WEST SUSSEX COUNTY COUNCIL CONSULTATION

TO:	Arun District Council FAO: Andrew Wood
FROM:	WSCC - Highways Authority
DATE:	18 February 2020
LOCATION:	Downsview Littlehampton Road Angmering BN12 6PW
SUBJECT:	A/16/20/PL Change of use from workshop to workshop storage space and first floor office space with external parking for works coaches.
DATE OF SITE VISIT:	n/a
RECOMMENDATION:	More Information
S106 CONTRIBUTION TOTAL:	n/a

SITE PLAN 1:500 @ A1

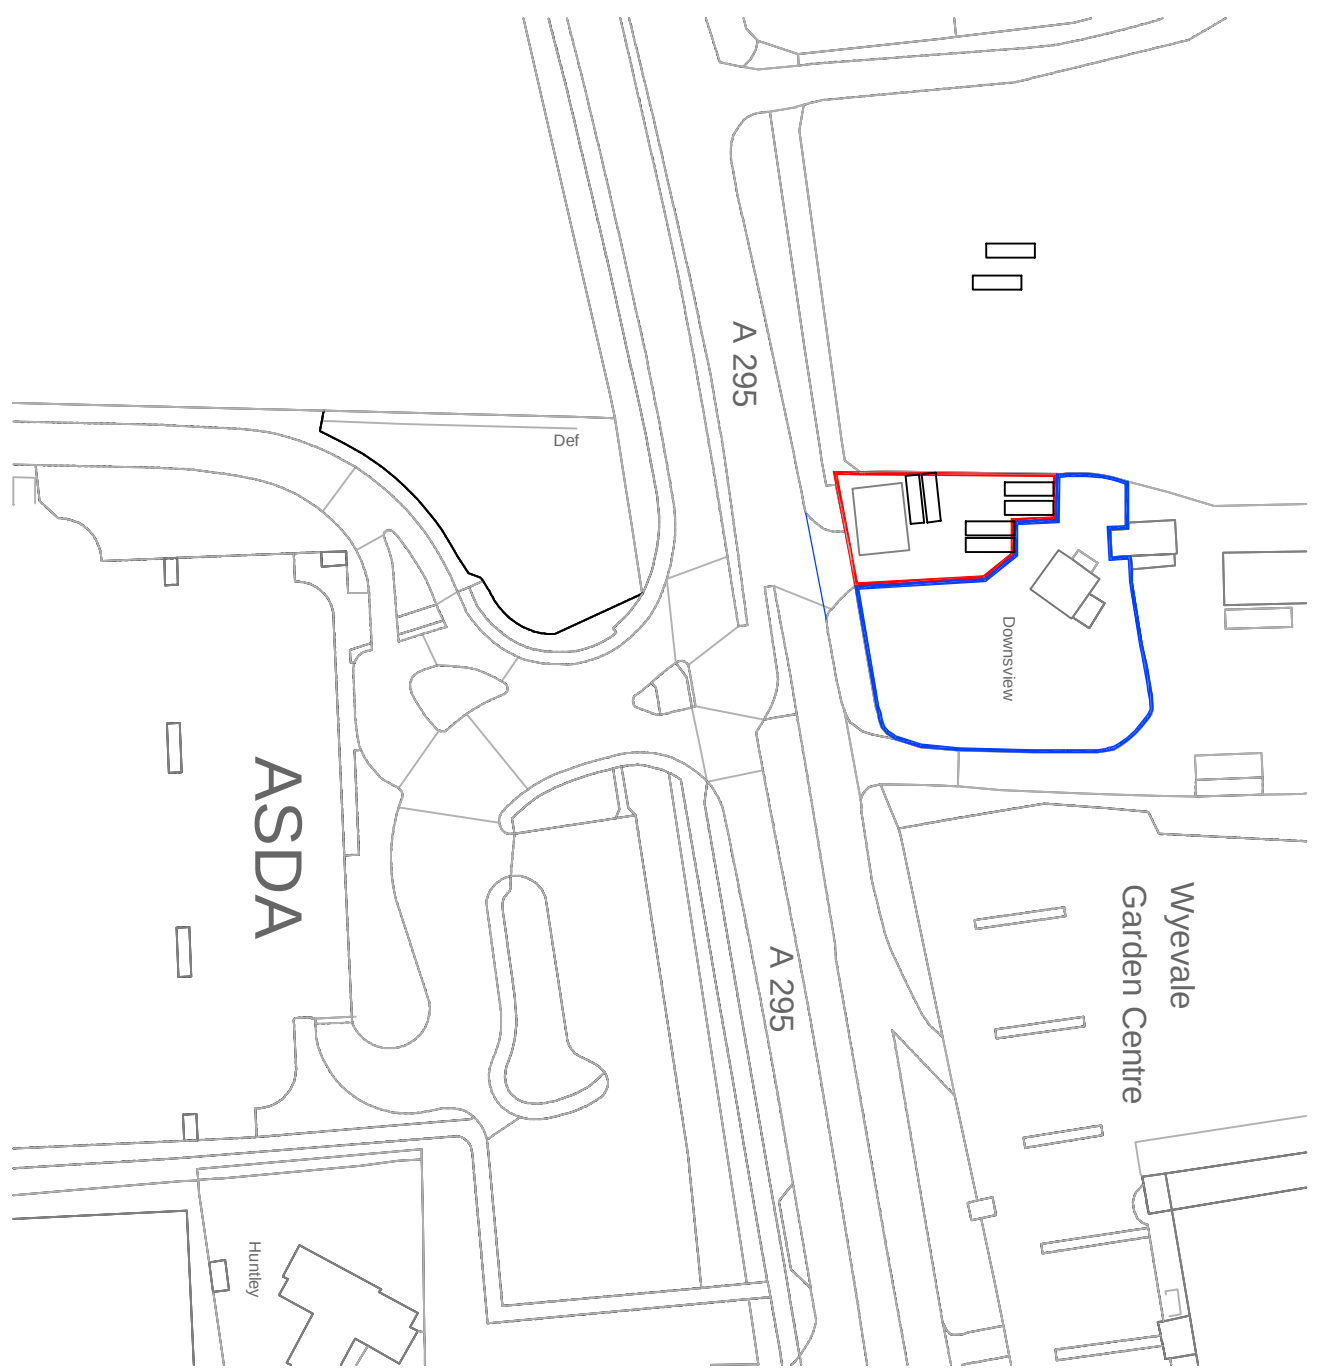
- The applicant has not demonstrated the existing access point's dimensions,
- The applicant has not provided anticipated Trips of the site both existing and proposed,

- The LHA asks what the applicant means by 'Works Coaches'?
